RE: INCA OFFICE BUILDING (C-17/D1M~~M~~) ENGINEER'S STAMP DATED
12/5/94

RE: INCA OFFICE BUILDING (C-17/D1MM) ENGINEER'S STAMP DATED 5/26/94

RE: INCA OFFICE BUILDING (C-17/D1MM) ENGINEER'S STAMP DATED 5/26/94

Based upon your 5/26/94 submittal, I have the following concerns which will need to be addressed prior to authorizing Building Permit approval.

INCA OFFICE BUILDING CLIFFORD INDUSTRIAL PARK GRADING AND DRAINAGE PLAN

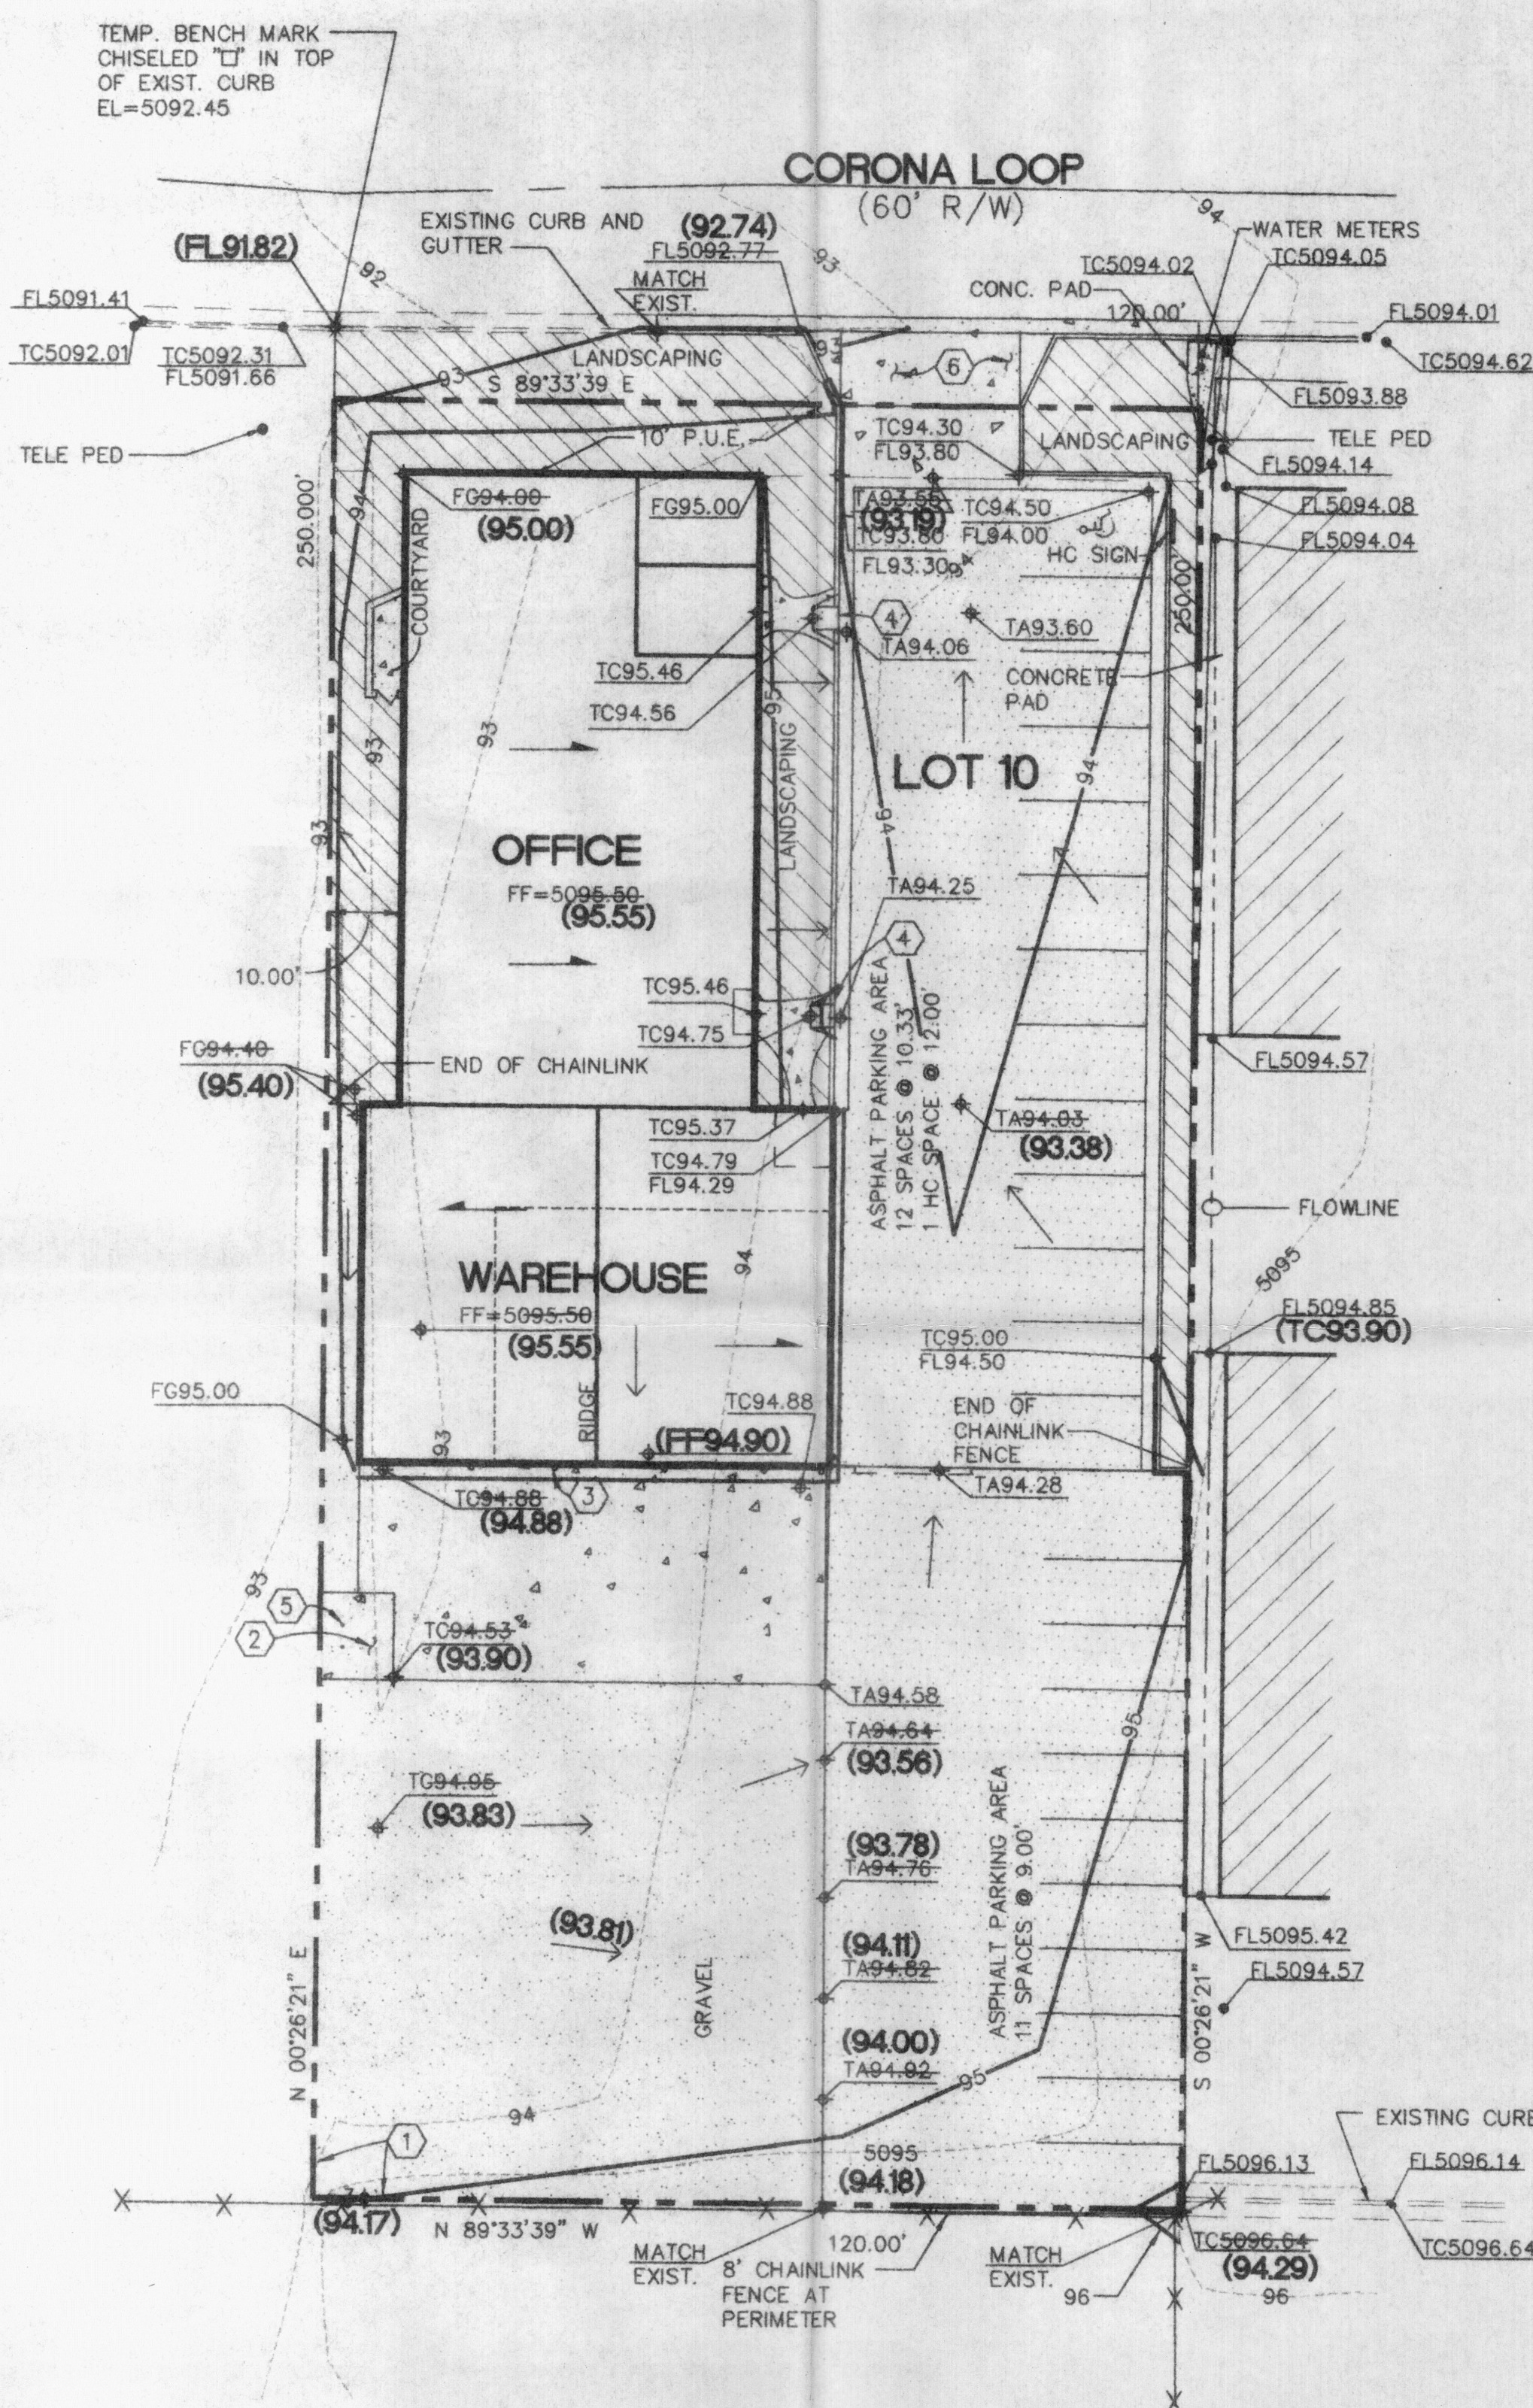
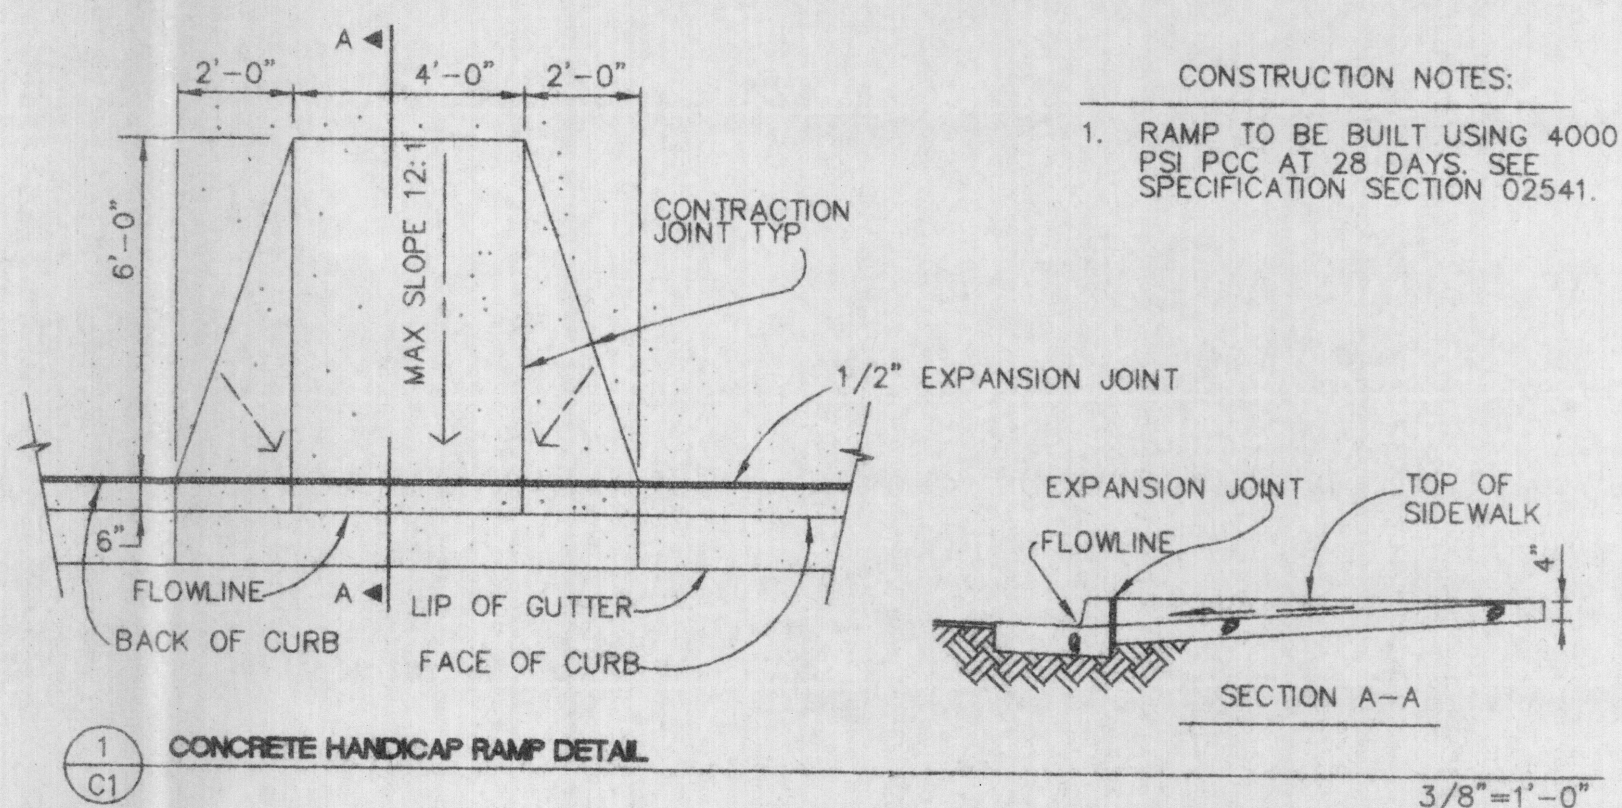
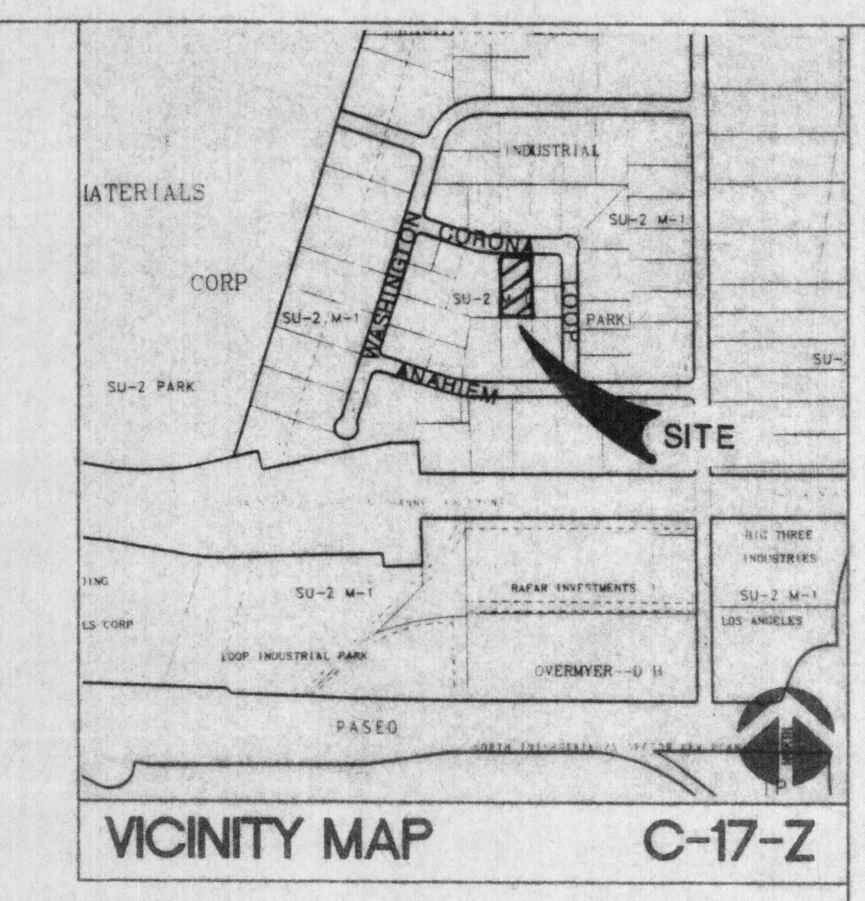
1. Please define in greater detail your proposed drainage plan. If you are requesting free discharge from your site, you will need to support your request with a description of downstream conditions. Specifically:
 - a) Is there a previously approved master drainage plan for the area which showed free developed discharge from this site? If so, please make reference to this plan.
 - b) Where does the water go once it leaves your site? Are there downstream floodplains? This information is vital in determining if you should be allowed free discharge from this site.
 - c) Is this site impacted by any offsite storm flows? If so, how are you proposing handling those flows?
